SDP - Comment Response Letter

Citizen on Constitution  
El Paso County, Colorado

Prepared: October 26th, 2022

PCD File Number: SF-226

C4.12

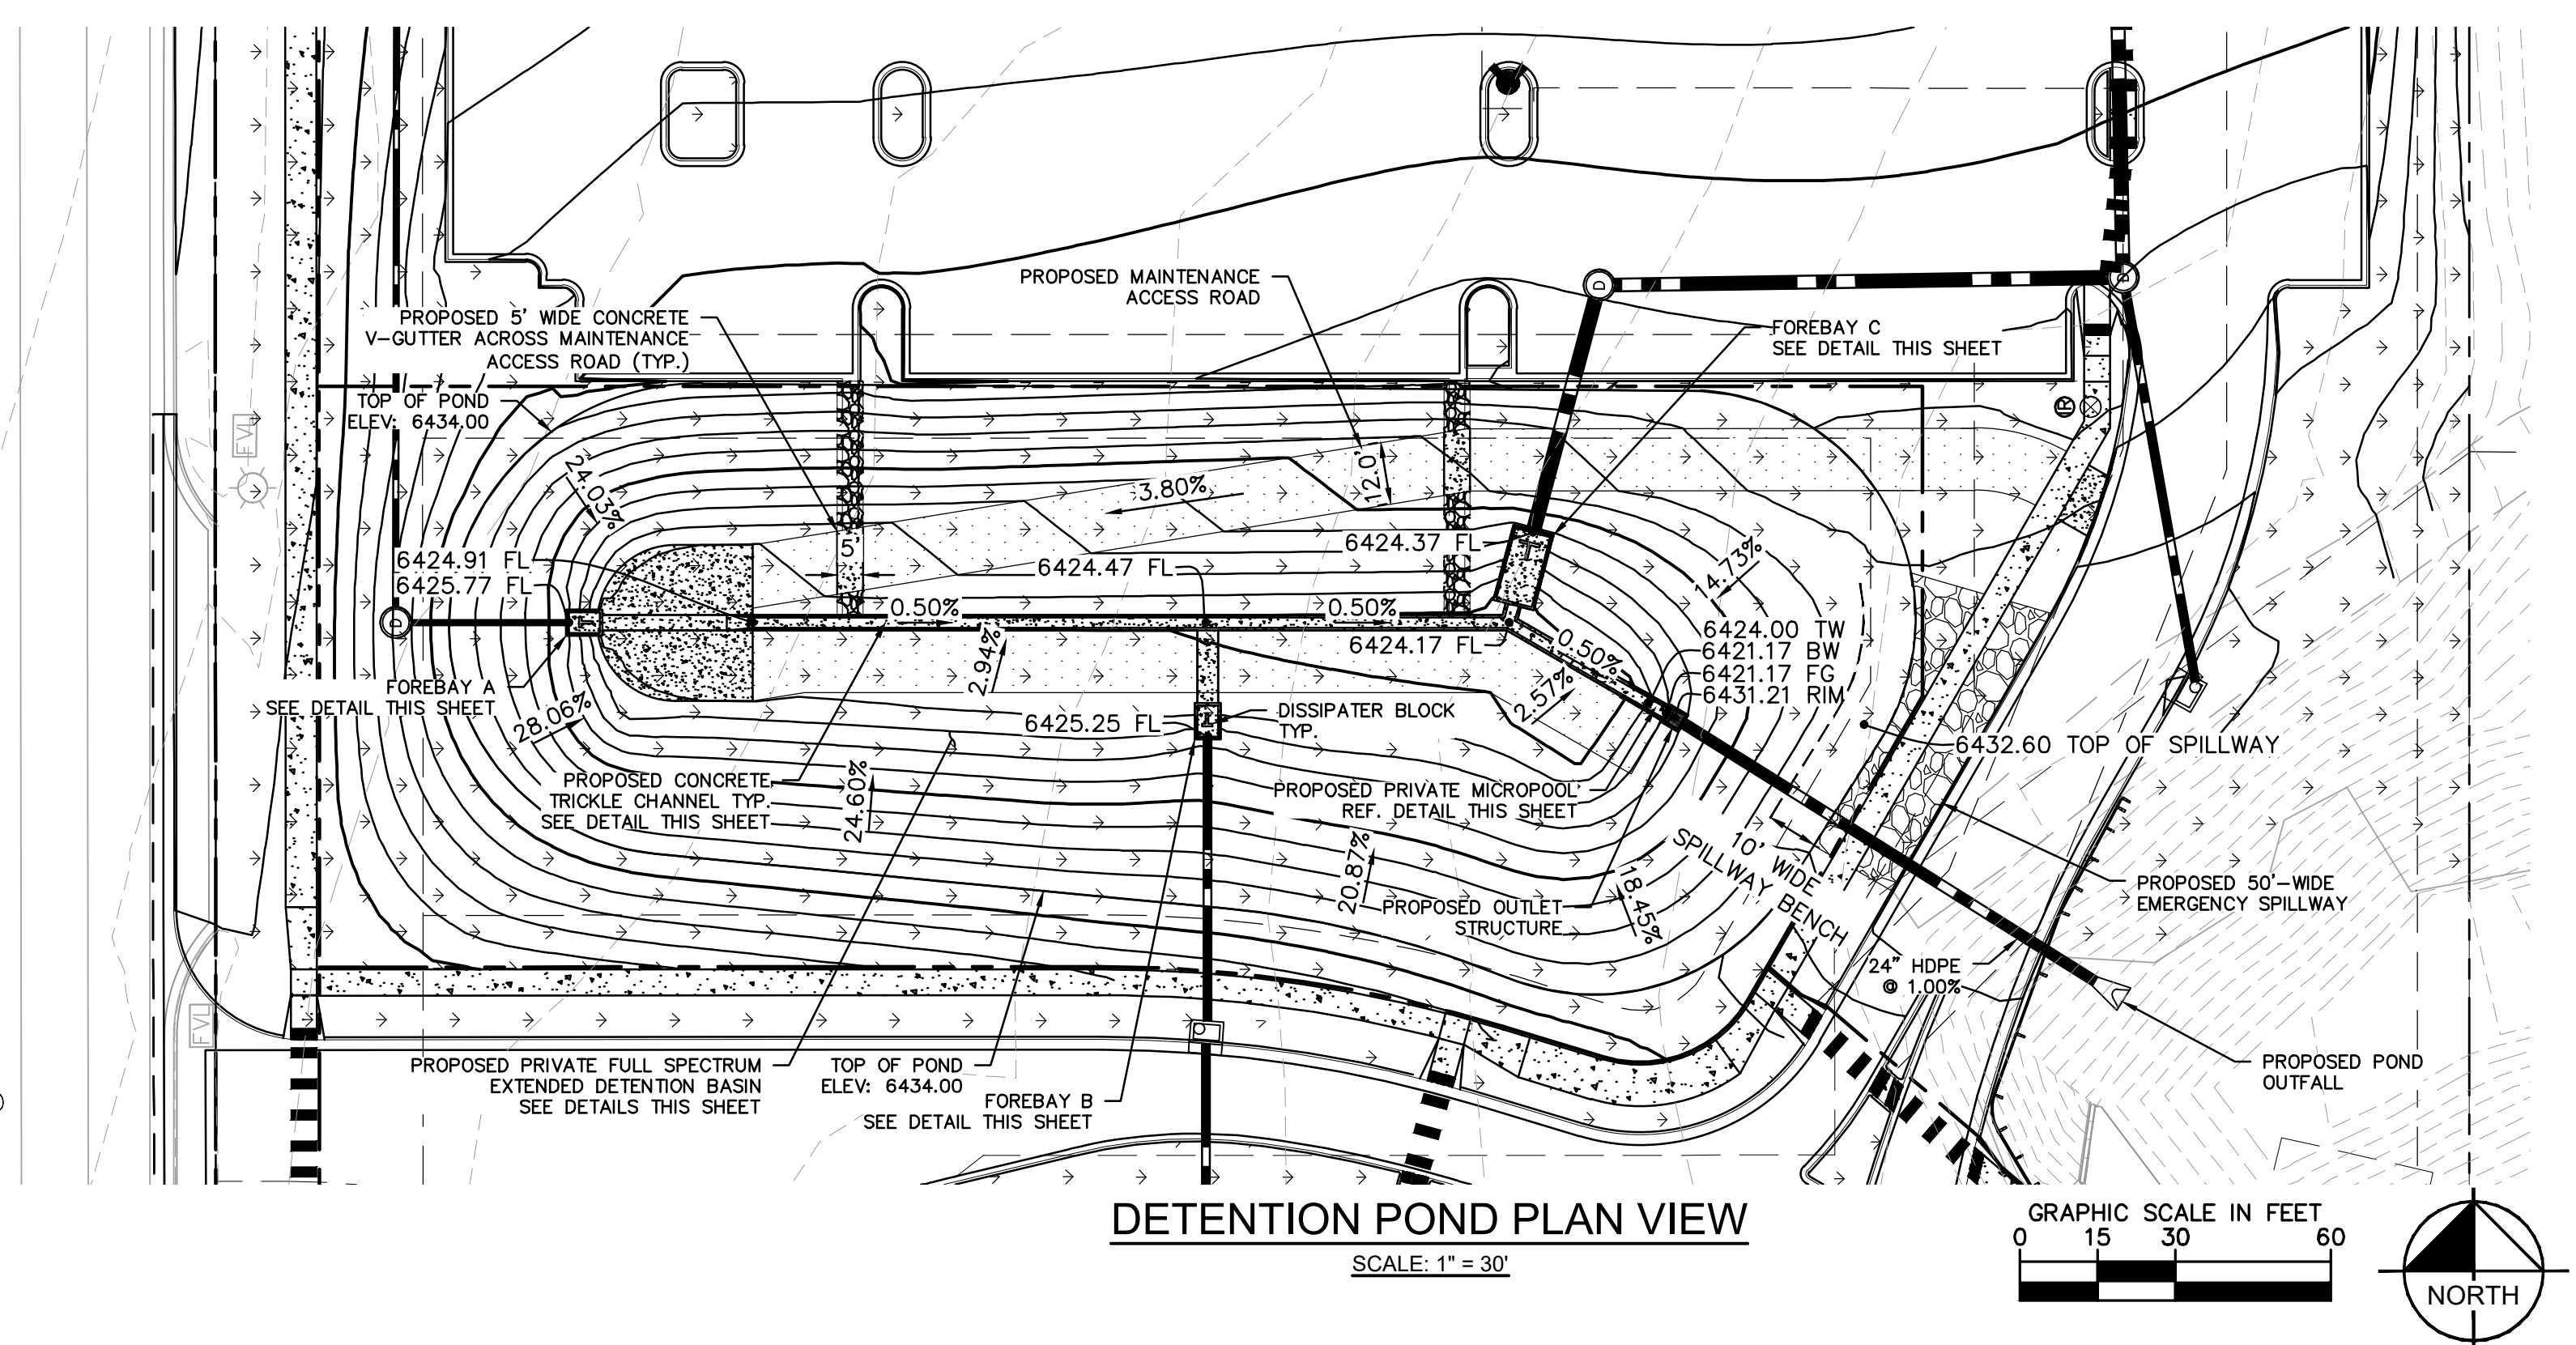
Revise as needed per comment on next sheet.  
KH Response: Grate elevation has been revised to 6431.10 to match UD Detention and the details that follow.
